CITY OF ALBUQUERQUE

**Re: Great Commission Alliance
1525 GIRARD NE
Traffic Circulation Layout
Architect's Stamp 3/12/2024 (J16D003)**

Based upon the information provided in your submittal received 5/6/2024, the above referenced plan cannot be approved for Building Permit until the following comments are addressed:

B3 BICYCLE RACK PLAN
SCALE: 1/4" = 1'-0"

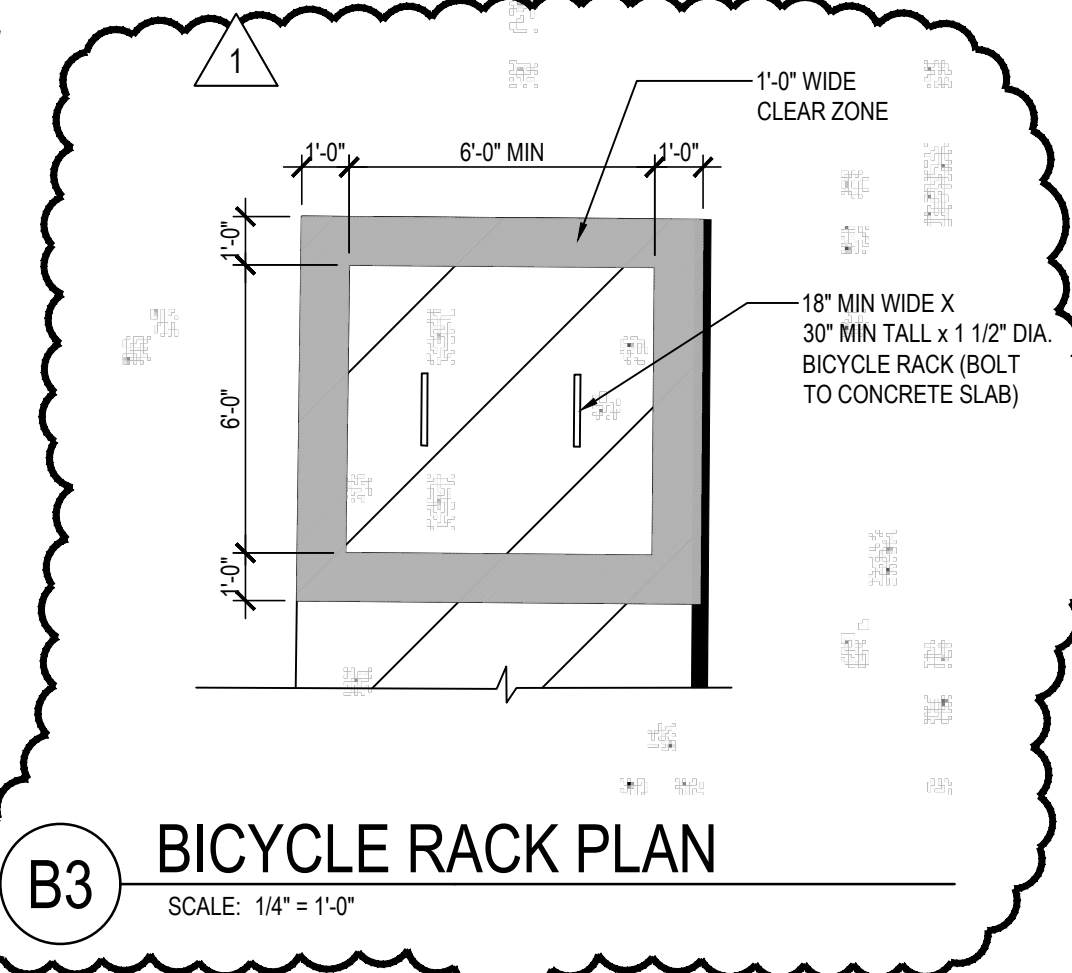
1. Add one Motorcycle parking space and shall be designated by its own conspicuously posted upright sign, either free-standing or wall mounted per the zoning code.
2. The pavement marking "MC" should be shown in the opposite direction for motorcycles entering the parking space.
3. Add 2 bicycle racks (3 spaces required) and shall be designed according to the following guidelines:
 - a. The rack shall be a minimum 30 inches tall and 18 inches wide.

- b. The bicycle frame shall be supported horizontally at two or more places. Comb/toaster racks are not allowed.
 - c. The rack shall be designed to support the bicycle in an upright position. See the IDO for additional information.
 - d. The rack allows varying bicycle frame sizes and styles to be attached.
 - e. The user is not required to lift the bicycle onto the bicycle rack.
 - f. Each bicycle parking space is accessible without moving another bicycle.
4. Bicycle racks shall be sturdy and anchored to a concrete pad.
 5. A 1-foot clear zone around the bicycle parking stall shall be provided.
 6. Bicycle parking spaces shall be at least 6 feet long and 2 feet wide.
 7. Refuse vehicle maneuvering shall be contained on-site. The refuse vehicle shall not back into the public right of way.; provide a copy of refuse approval.
